Notes of todays meeitng

Key points from todays Site Plan Review meeting with MMC:

East Tower CMP - meeting was seeking to find consensus

Congress Street Closure and associated detours/emergency access (this discussion to continue longer; includes third party review of construction plan)

[ Visitors Garage ] Logistics Plans and Studies

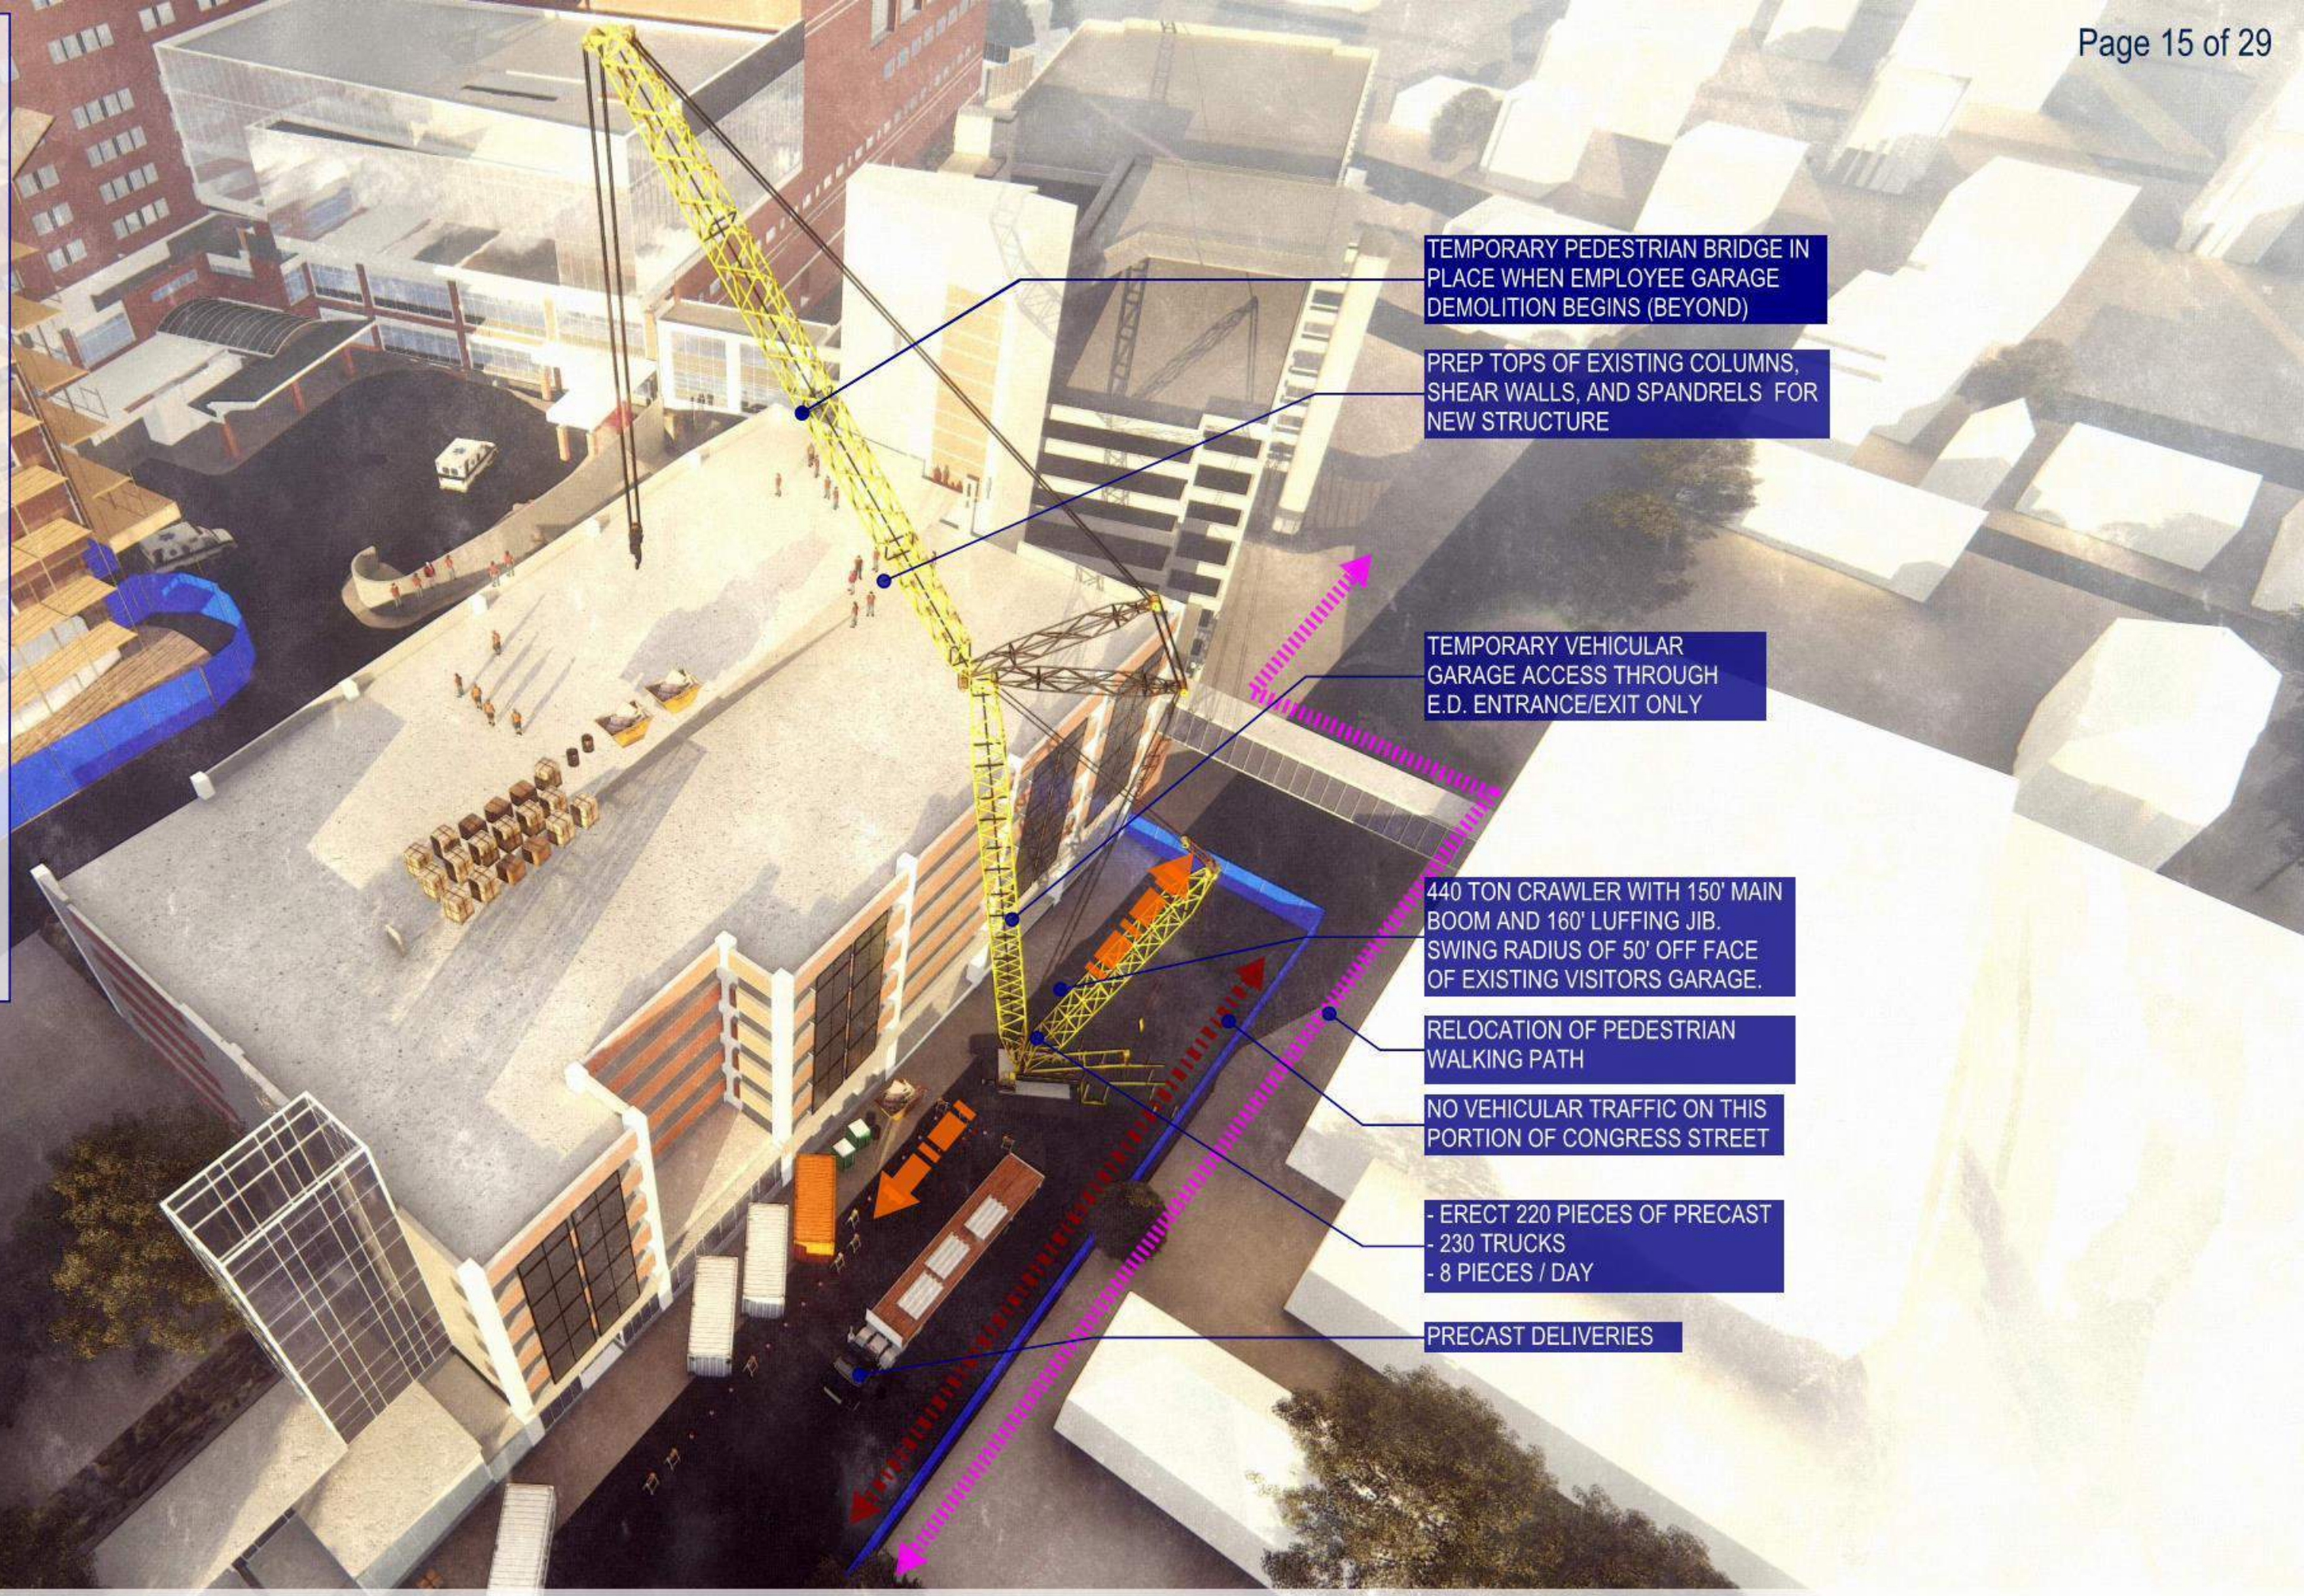
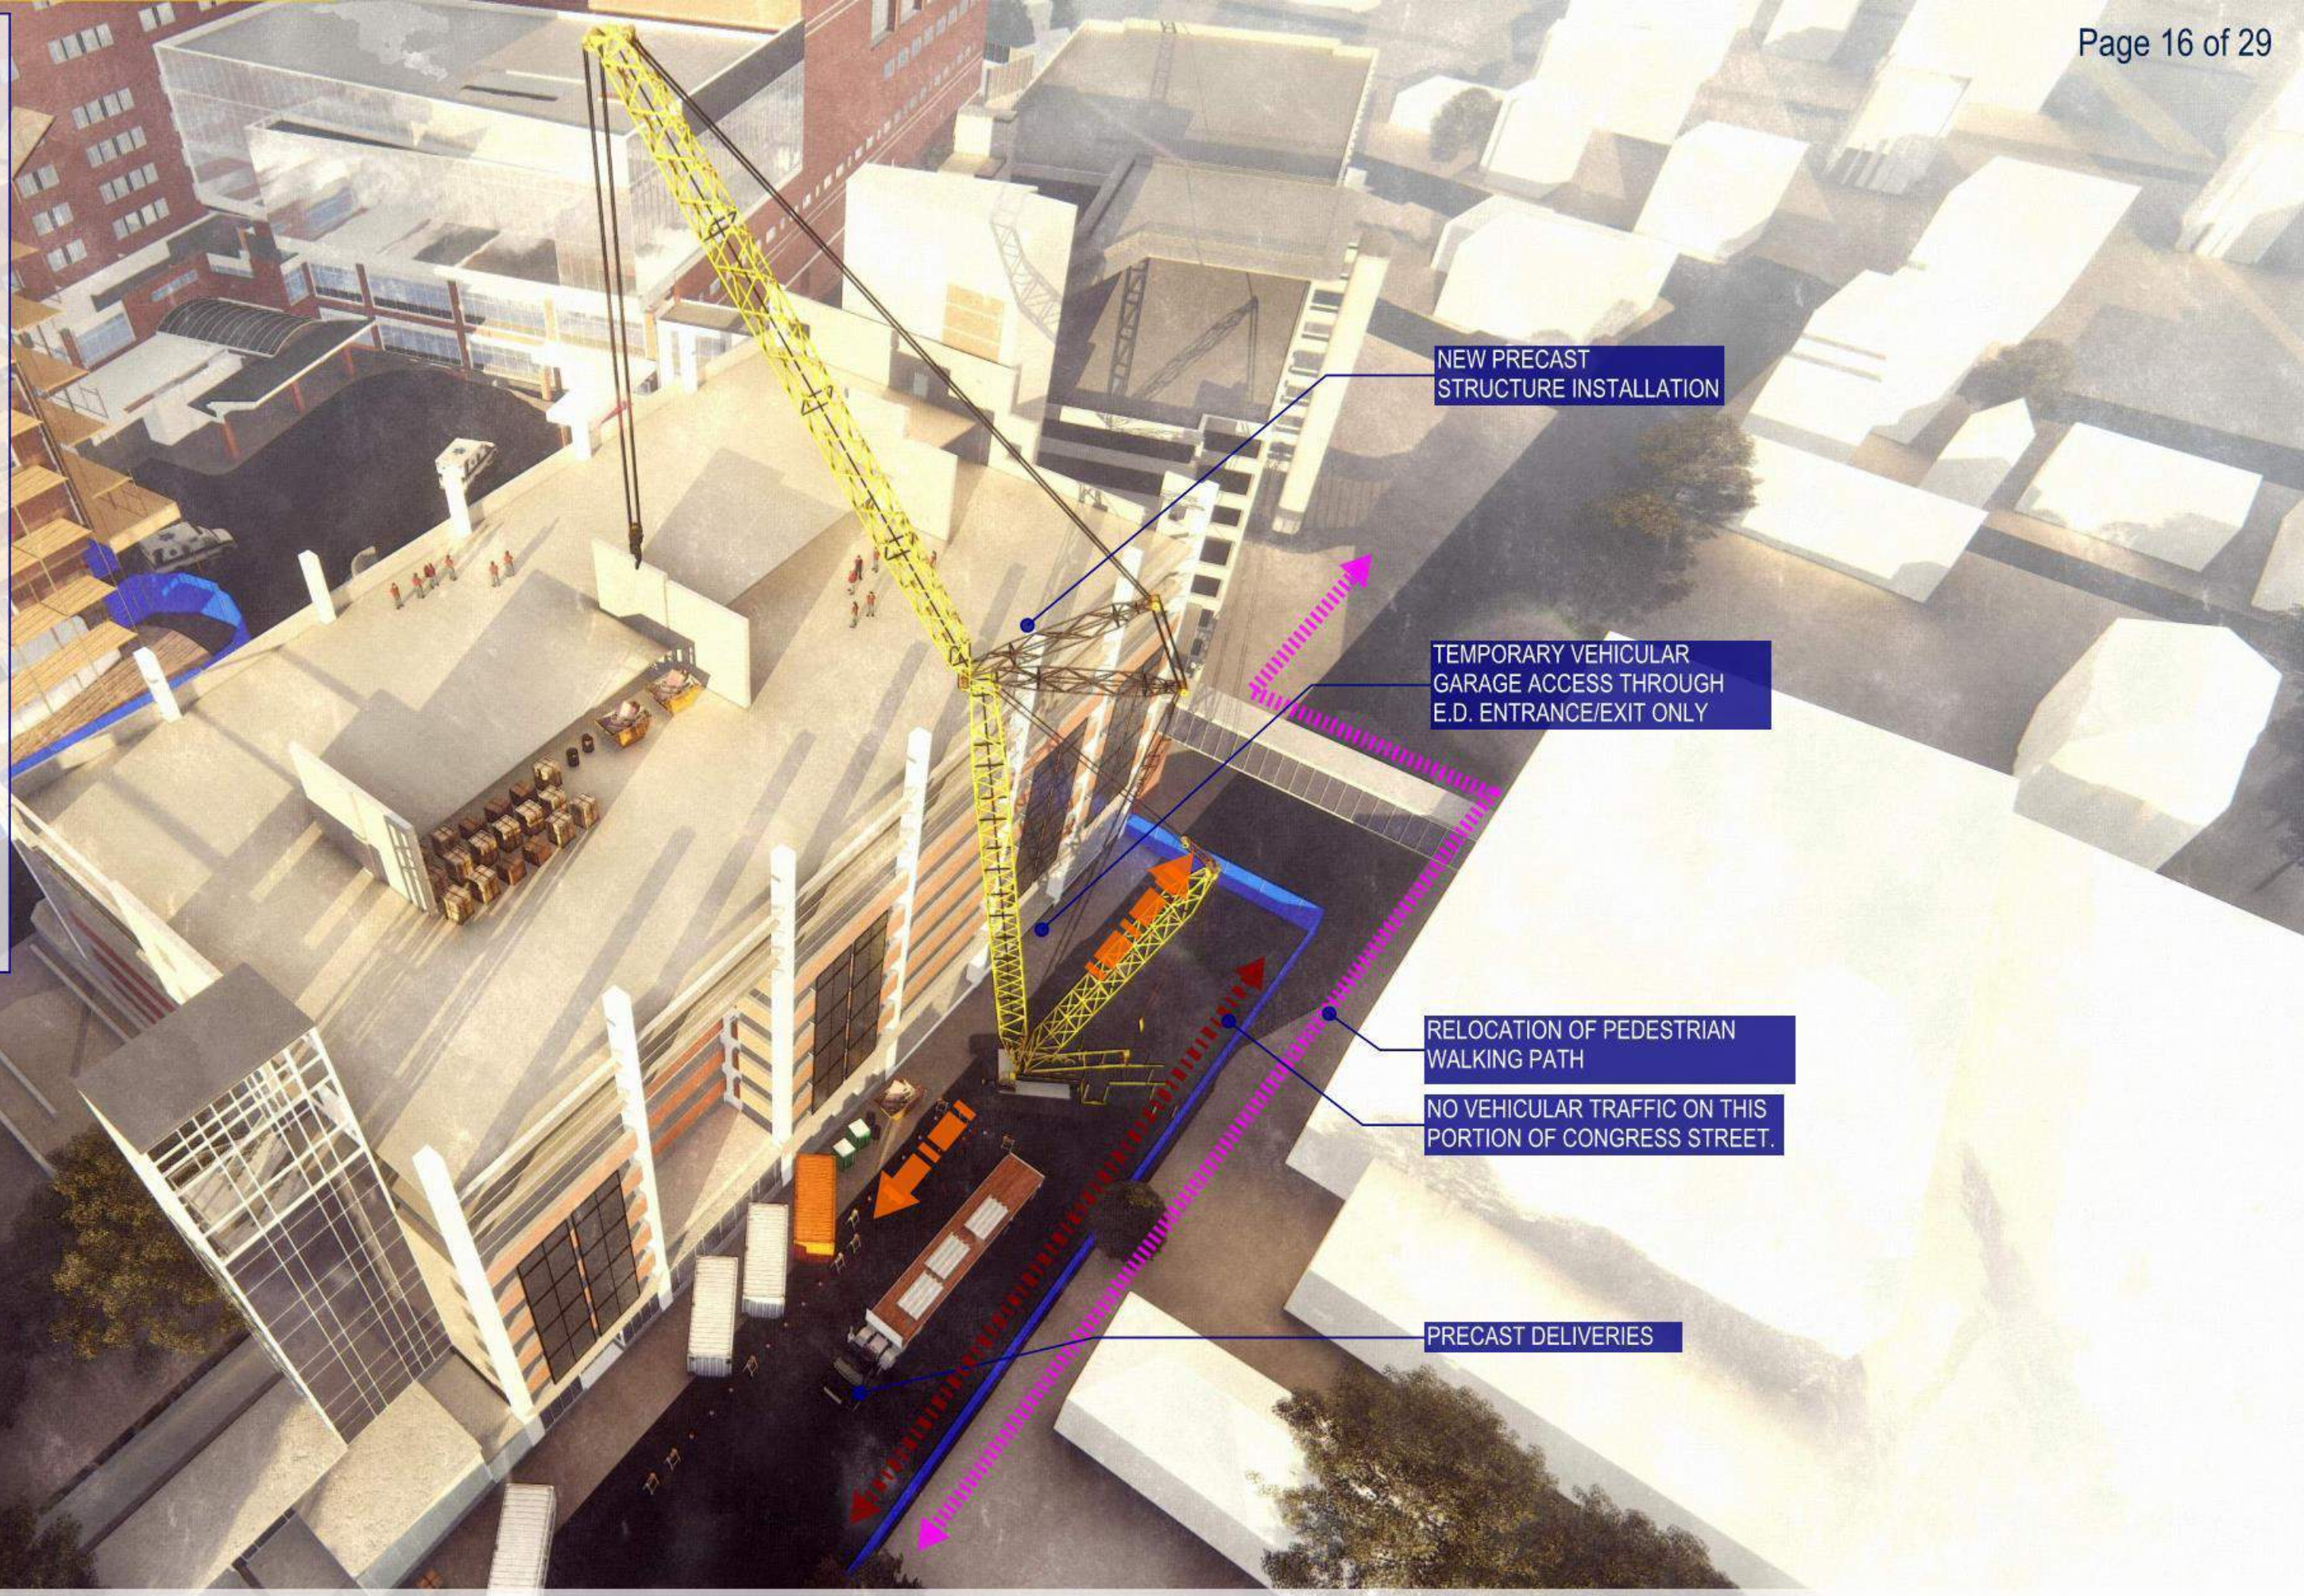
- A number of alternatives were discussed, looking at pros and cons (eg access from Gilman) as Turner proposals problematic Ellsworth to Congress and reservations over 2-way in Crescent
- MMC noted secondary access via employee garage for cars going to Visitors Garage
- Concluded:
 - Take out bumpout in Crescent to help larger emergency vehicles
 - Best option for exiting trucks is Bramhall via Charles to 295
 - Keep Crescent 2-way (MMC contacting residents long here re need to remove parking)
 - Gilman could be back up access option and arranged if necessary

- Current plan is for 8 week closure based on normal working practices, so May 7 to June 28 envisaged
- Compression of time means more trucks in area per day

- Need to get people out of system further out - need signage
- Police suggest closures on Congress at St John, and Park
- Many felt should avoid pushing traffic to Weymouth
- Deering another option - G-P to include in analysis
- Park 2-way offers benefits but big questions re intersection modifications and signals
